**South Humber Bank Energy Centre ("SHBEC") – EN010107**

**Section 51 Advice – Draft Application Documents Submitted by EP Waste Management Limited ("EPWM") for PINS Review**

**EPWM Responses – 10 March 2020**

TITLE: **SOUTH HUMBER BANK ENERGY CENTRE ORDER ACCESS & RIGHTS OF WAY PLAN**

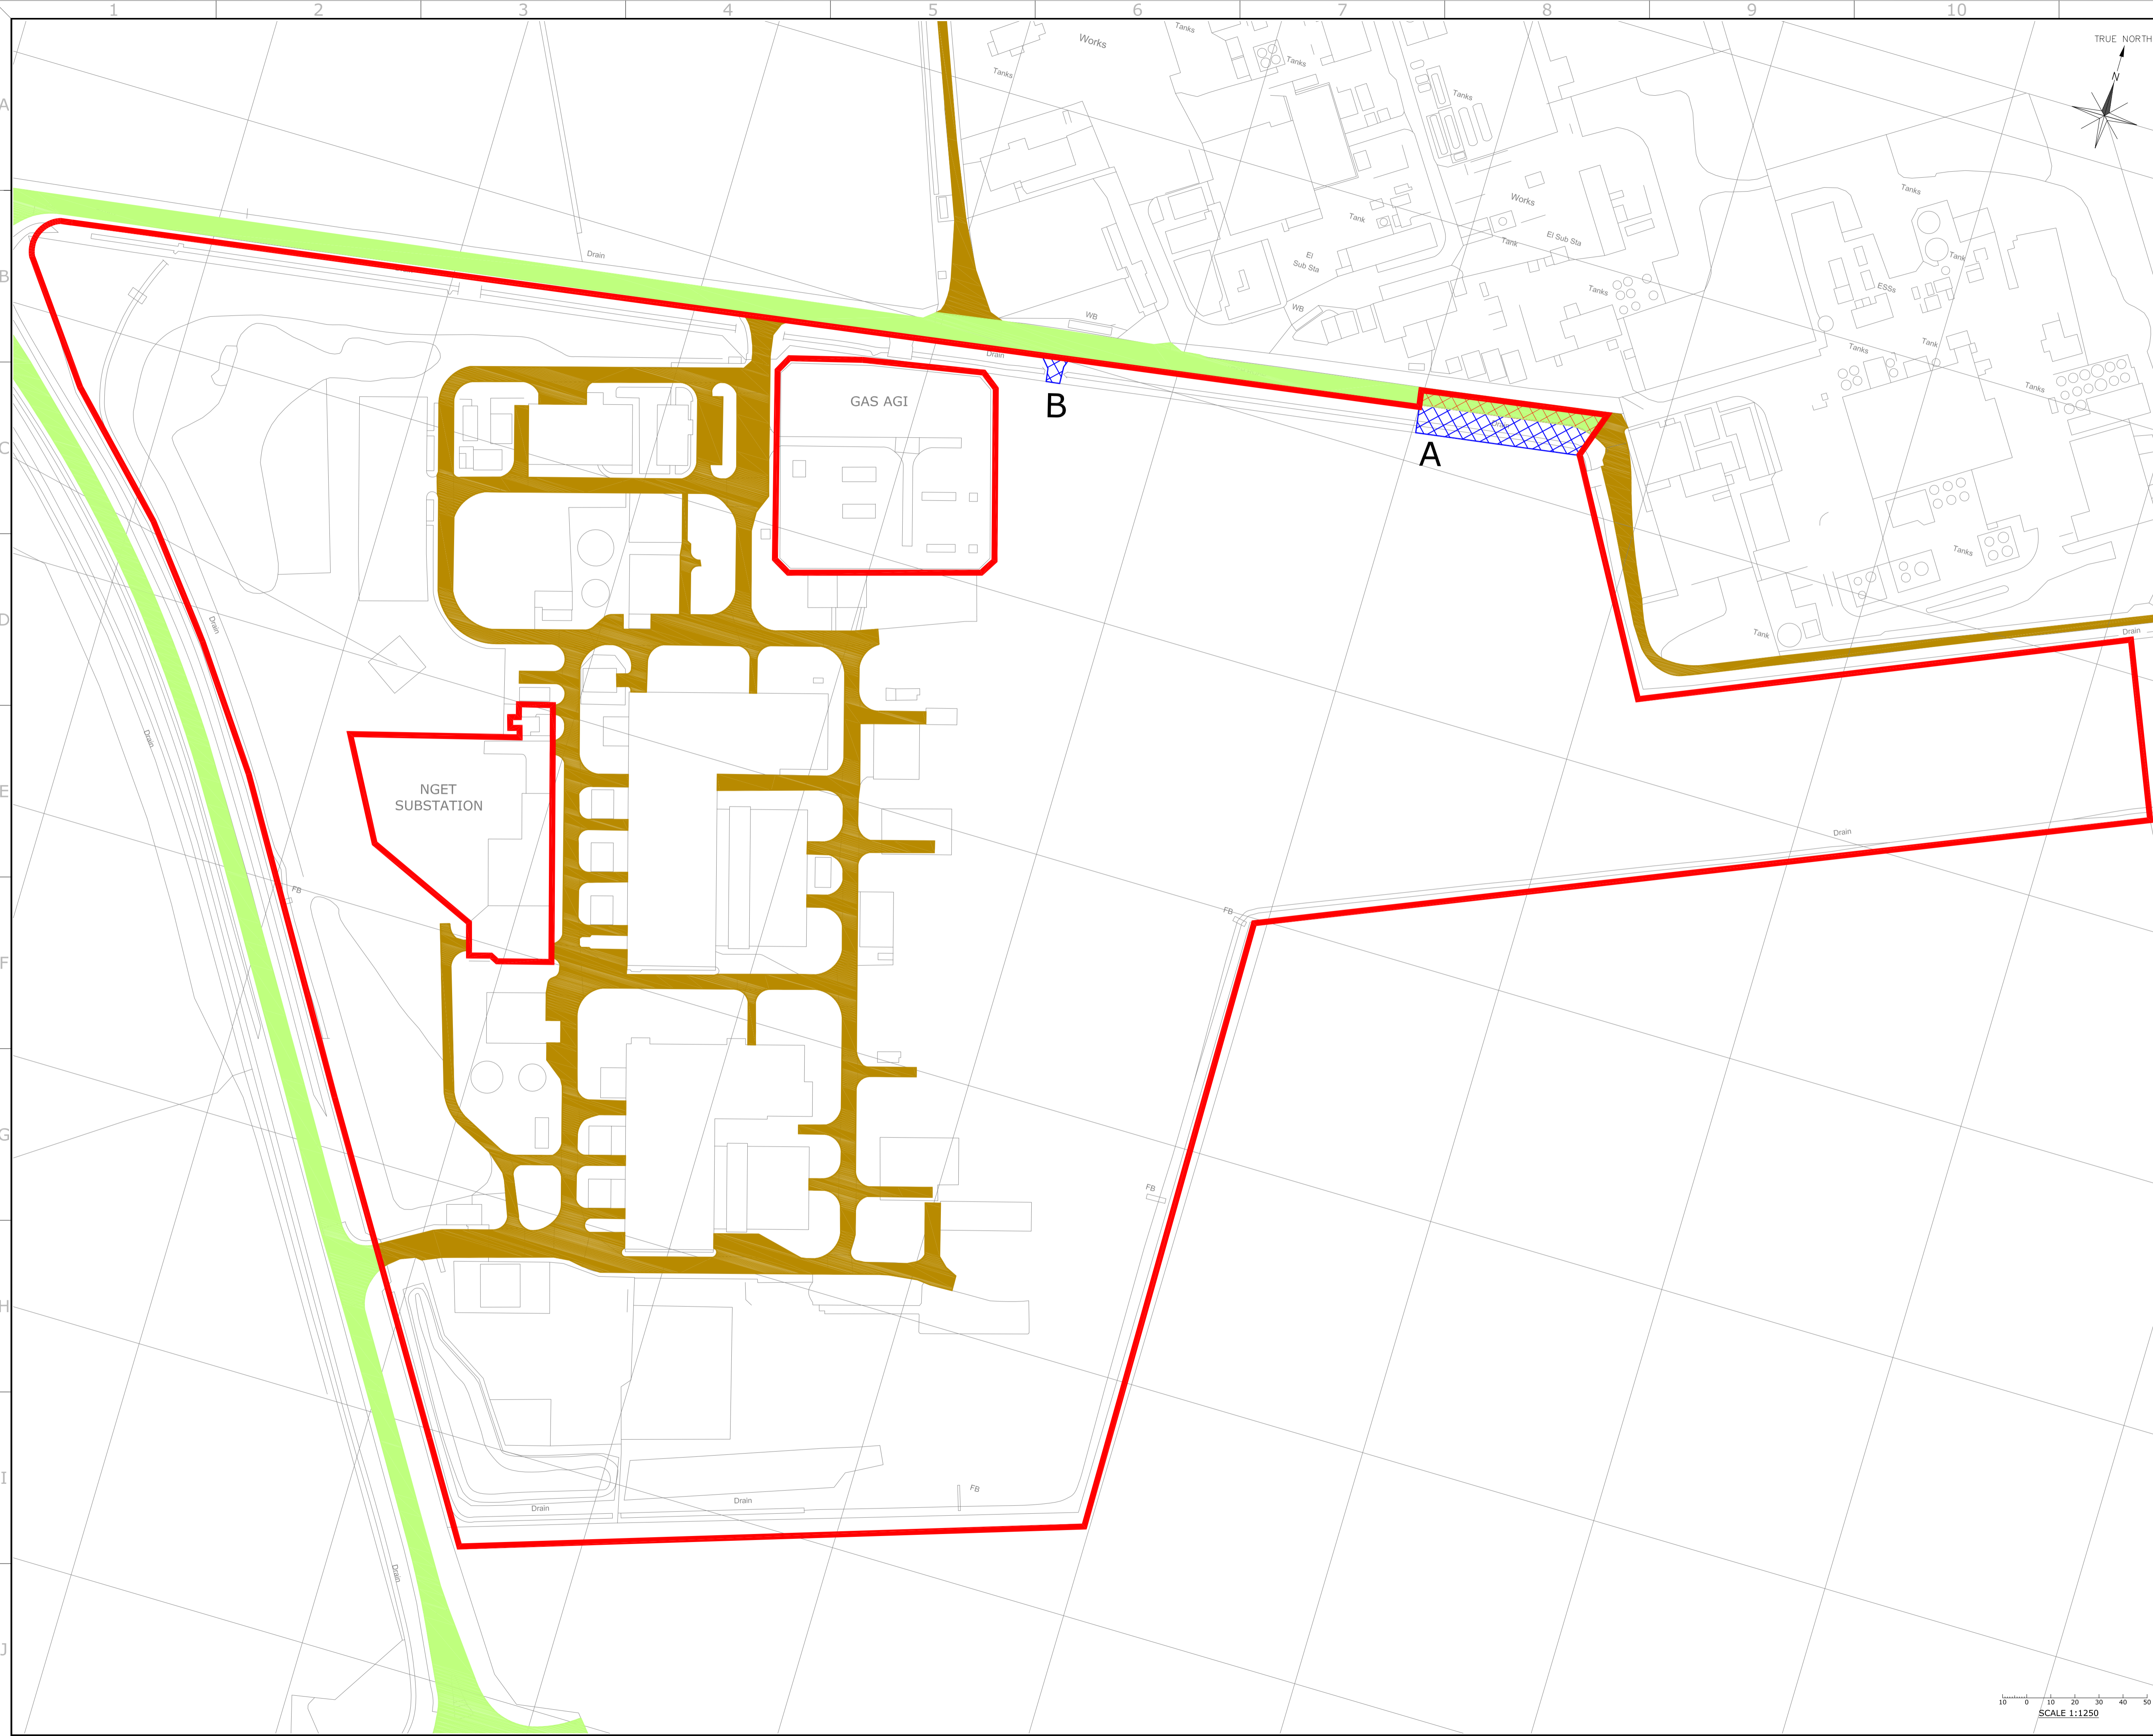
Access and Right of Way Plans			
Q No.	Plan Ref	Question / Comments	EPWM Response
1.		The public and private maintenance of access appears to be confusing. It is unclear why the public maintenance of access would be inside the red line boundary. The Applicant should ensure that this is explained.	<p>The Order limits cover the area within which works are to take place, as part of the authorised development. The Order limits include areas which are currently public highway and areas which are not.</p> <p>The areas to be maintained publicly are the same as at present.</p>

2.		The Applicant has not explained why the letter A is included. The Applicant should ensure that this is explained.	The key has been updated to cross refer to the Schedules to the DCO (where the letters are used to identify the works).

3.		In the south west corner there appears to be an access road but no maintenance has been assigned to it. The Applicant should ensure that this is explained.	This is an existing entrance. No works are proposed here and there is no proposed change to maintenance arrangements.

Access and Right of Way Plans			
Q No.	Plan Ref	Question / Comments	EPWM Response
4.		On the Works Plan there is a second access marked on South Marsh Road that is not highlighted on the Access and Rights of Way Plan. The Applicant should ensure that this is explained.	The ARoW Plan has been updated to include the second access. The relevant streets schedules to the DCO will be updated prior to submission to refer to point B as required.
5.		There is an area excluded at the top of the red line boundary on all plans which is not clarified. The Applicant should ensure that this is explained.	See earlier comment.
